**ADC Planning Consultation
Response from the Historic Buildings Adviser**

Application Number	WA/87/11
Address	Bramble Barn, Binstead
Description	Proposed Orangery
Case Officer	Janice Chapman
Site Visit	7 December 2011

REV	DRAWN	DATE	DESCRIPTION
CLIENT			
Mr T Lysak and Mrs C Connolly			
SITE ADDRESS			
Bramble Barn			
Binstead Lane			
Binstead			
West Sussex			
BN18 0LQ			
DRAWING TITLE			
Proposed Orangerie			
SCALE			
As shown			
DATE			
September 2011			
REFERENCE			
31 Penfold Way			
DRAWING No.		REV.	
001

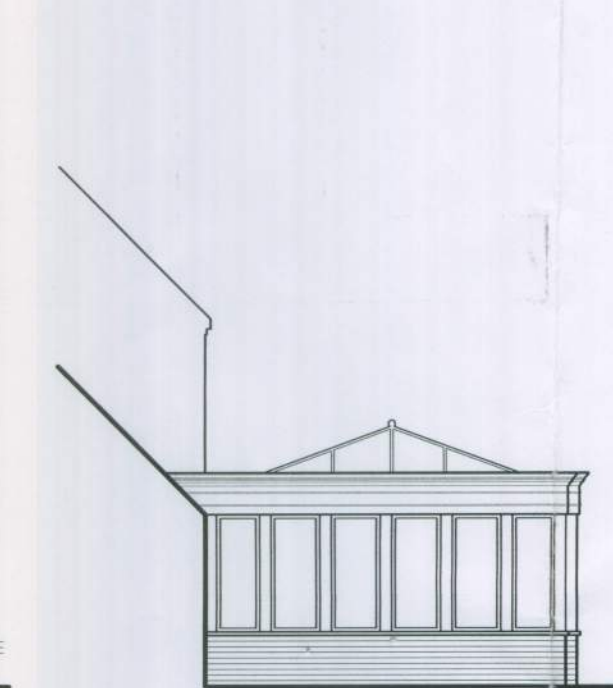
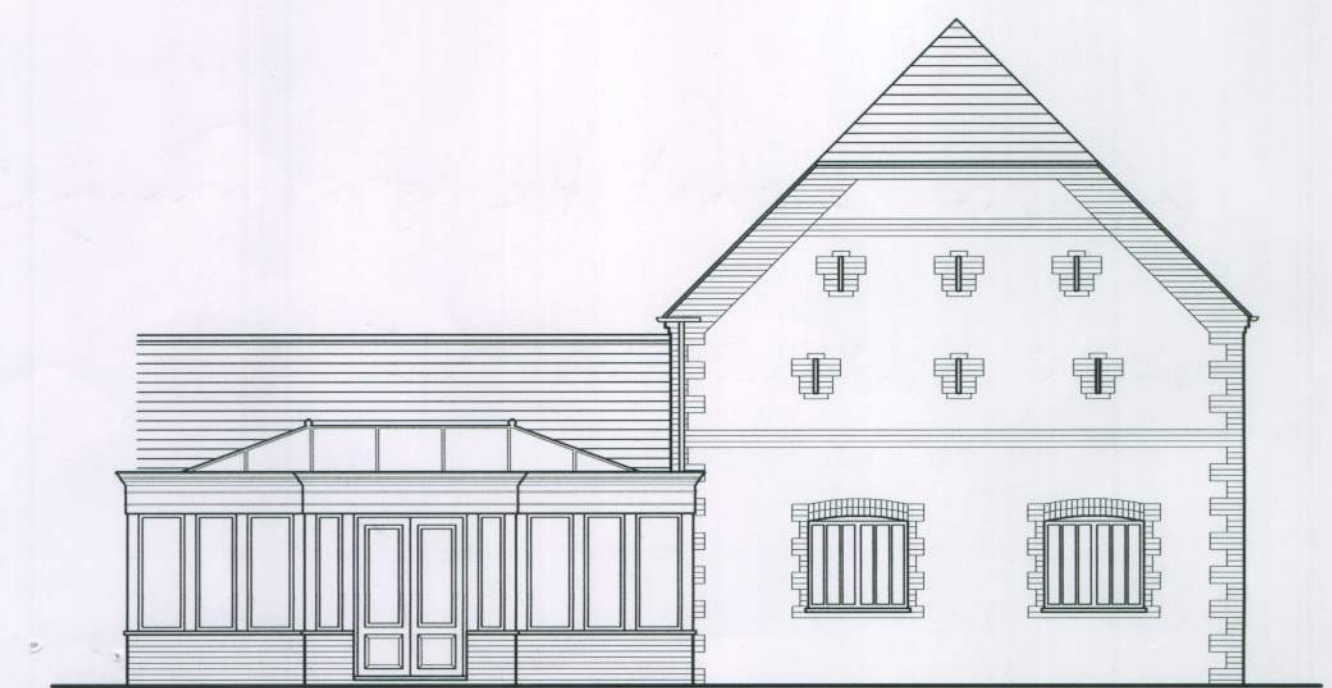
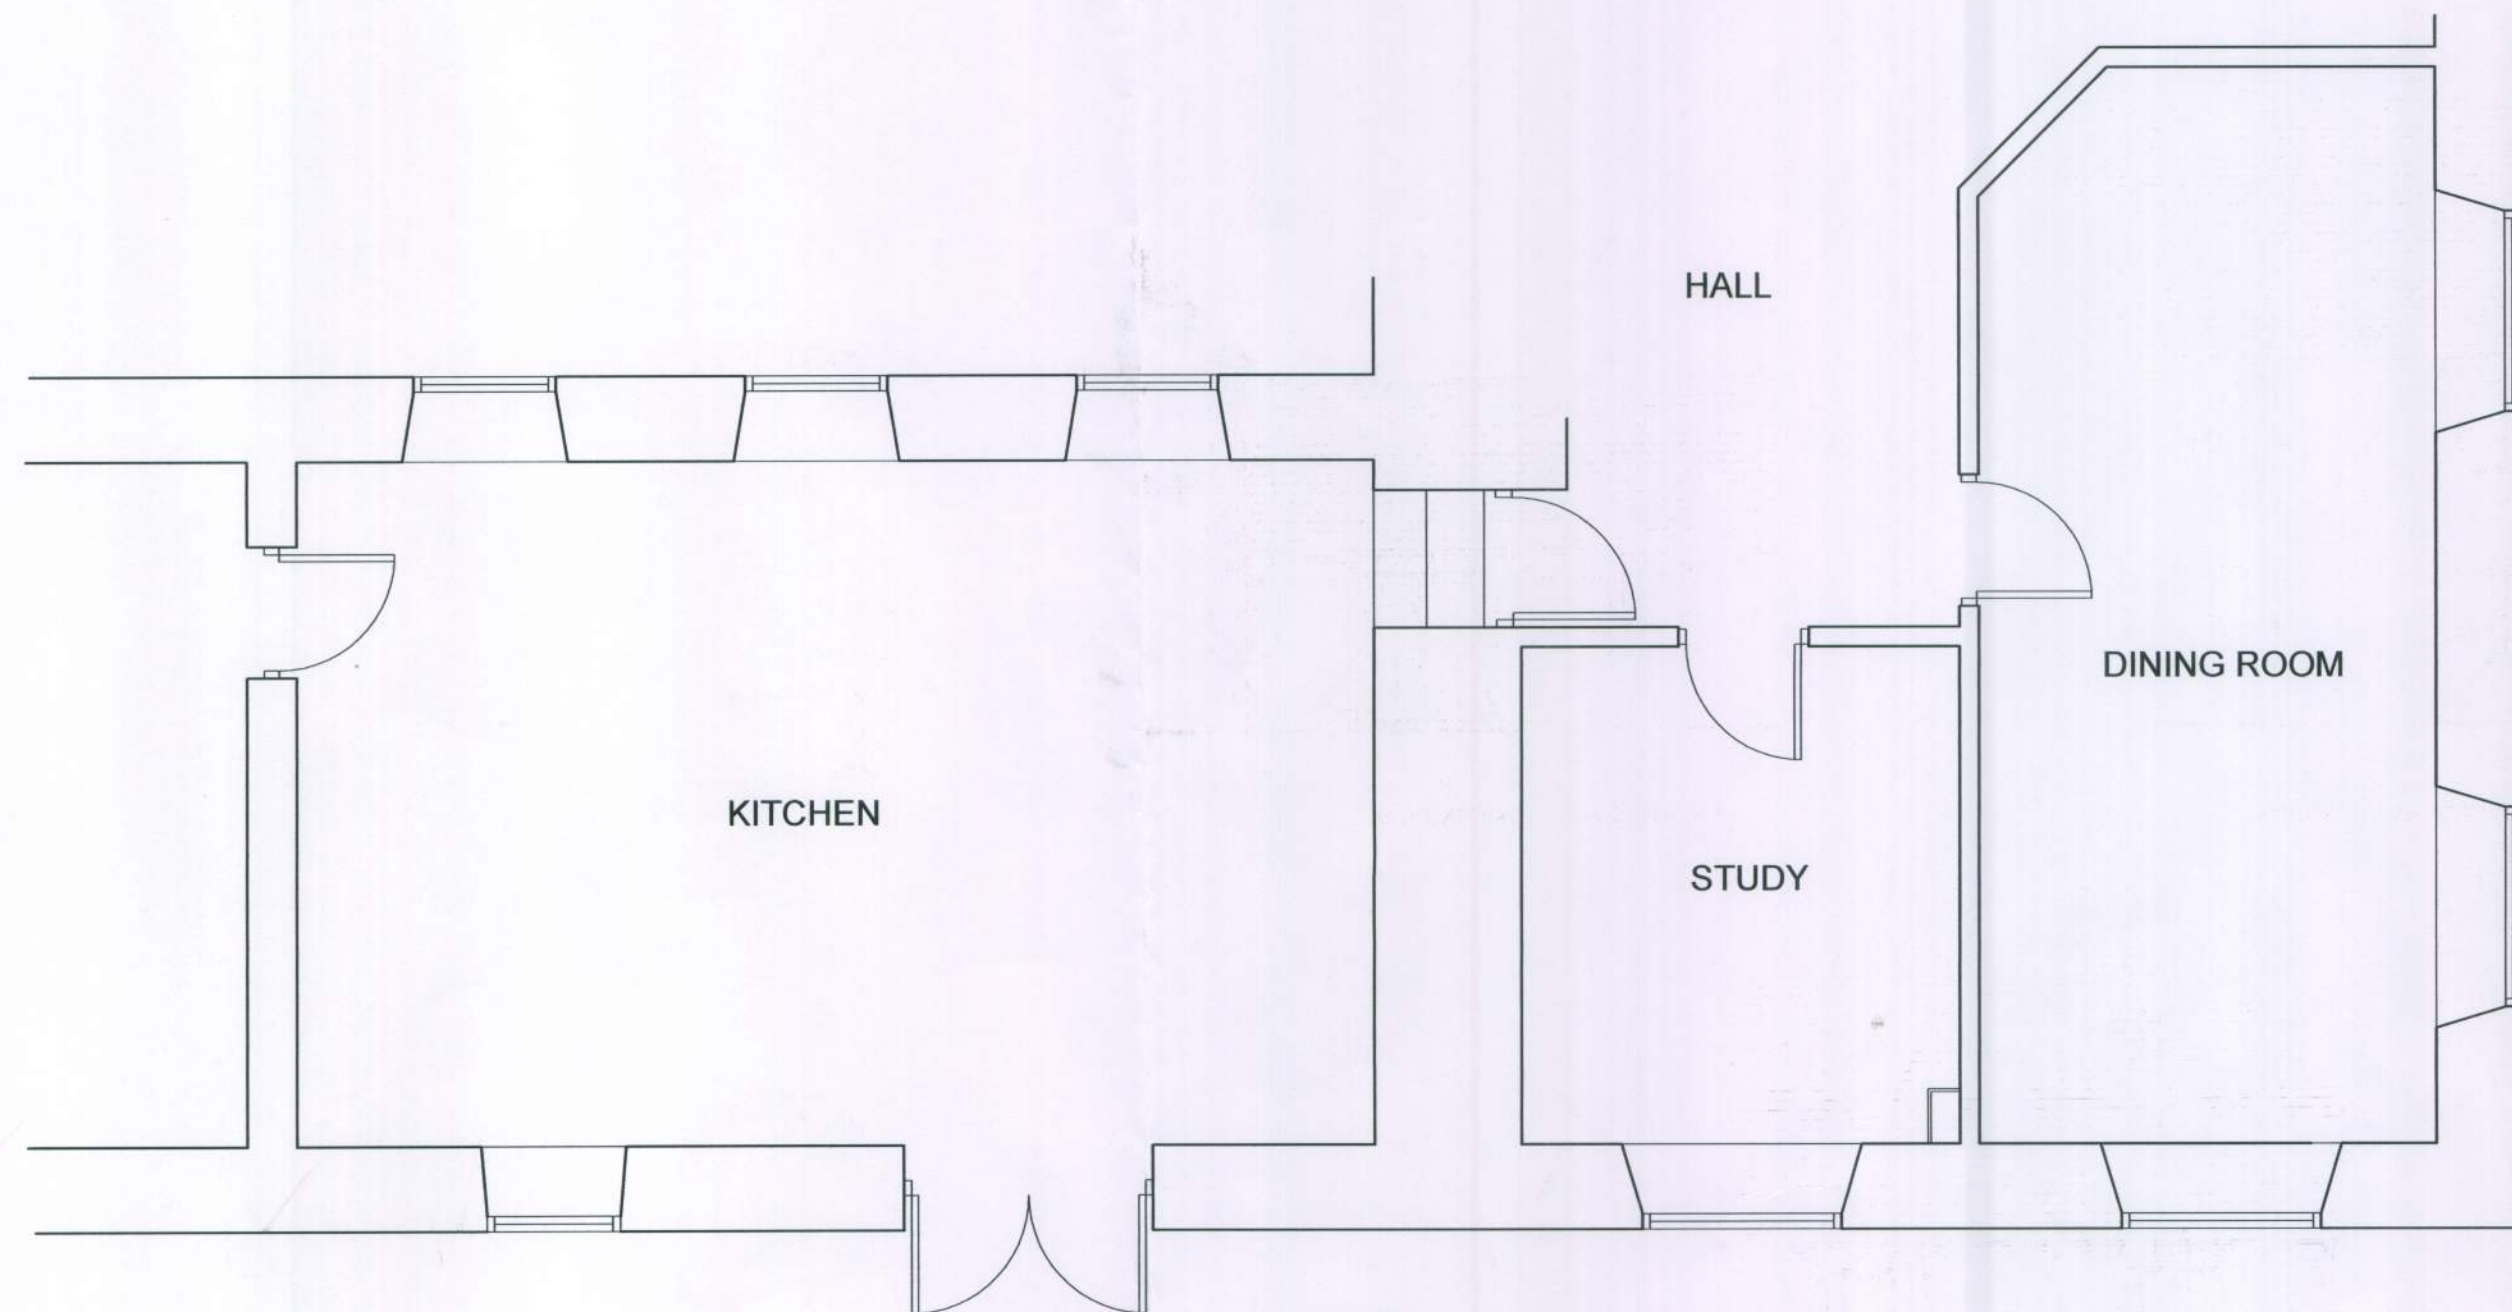
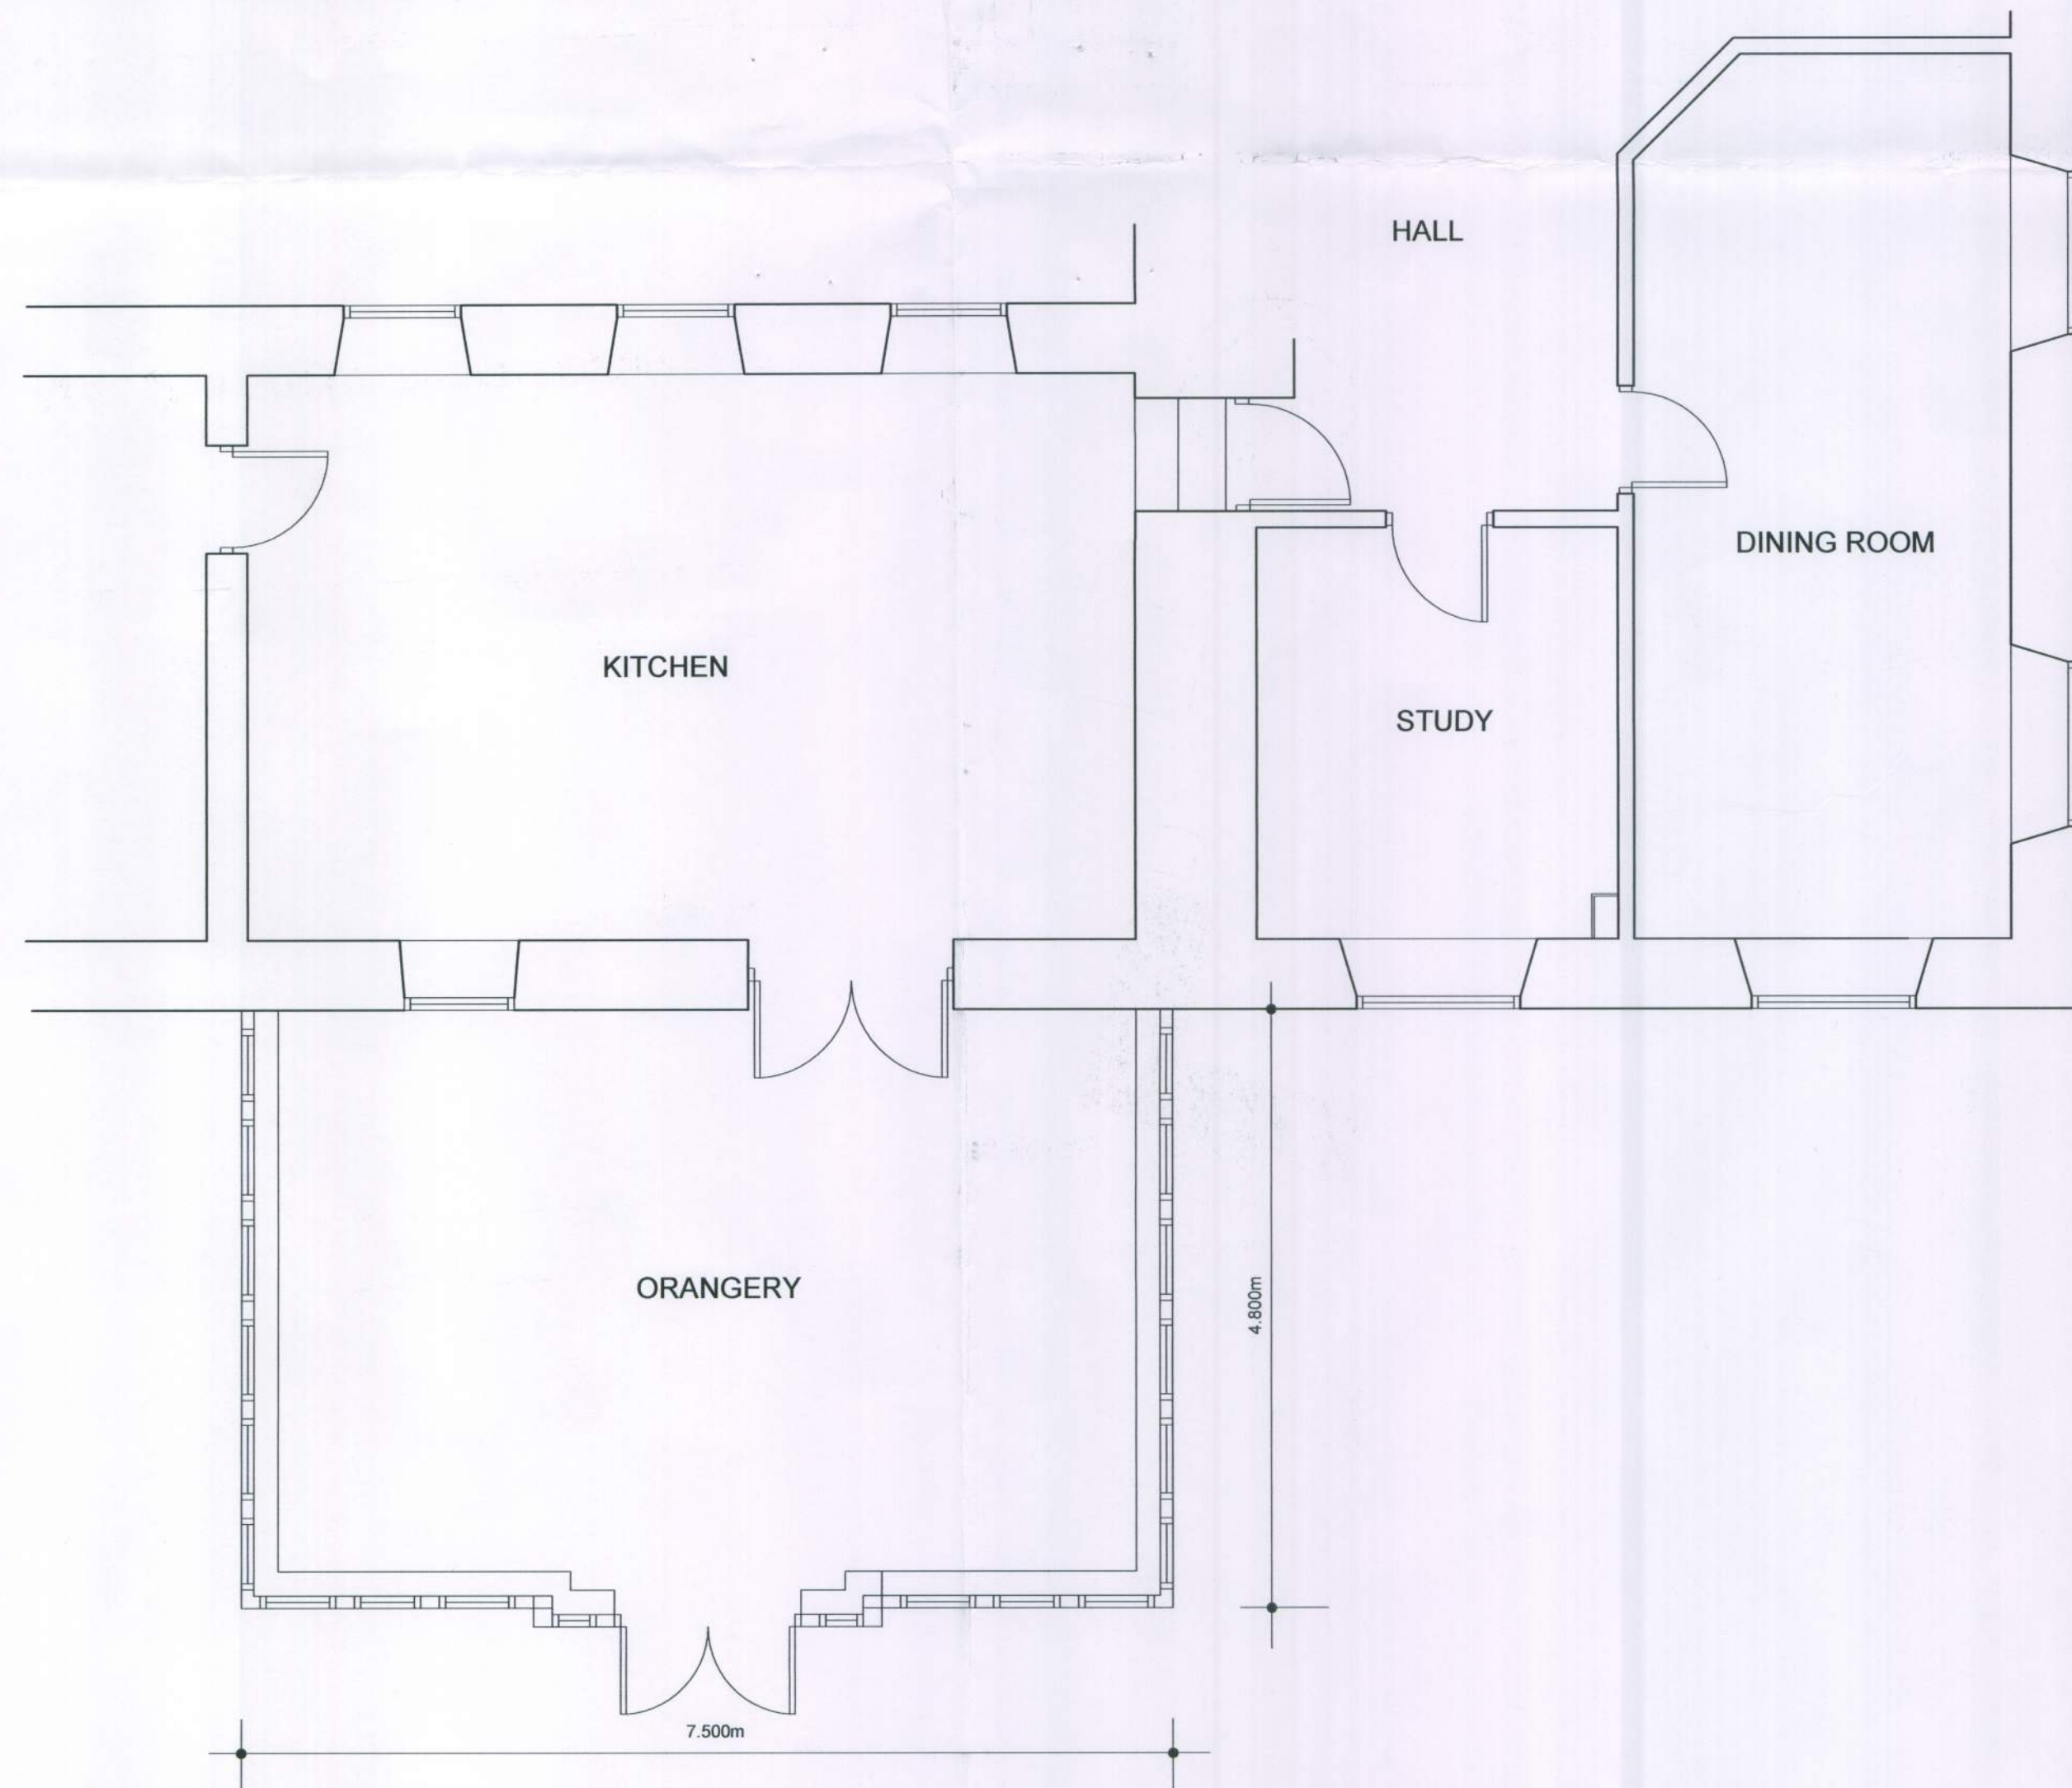
The main issue with this scheme is the design, if not the concept of attaching an orangery to a barn. Orangeries by their very nature are traditionally a high status structure associated with larger houses. They were particularly popular from the 17th to the 19th centuries and more often were classical in style and detail. Modern orangeries tend to continue to borrow from this tradition.

On the contrary, barns are agricultural, commercial buildings that are generally vernacular in form and material. They are completely different in terms of character, appearance and status. Bringing the two together is therefore inappropriate and cannot be recommended.

If anything is to be permitted here, it should be a design that is reflective of the host building's more vernacular origins and rural position. In this respect an oak timber-framed structure with a pitch roof is likely to be more sympathetic as an addition. This of course would be subject to scale and design.
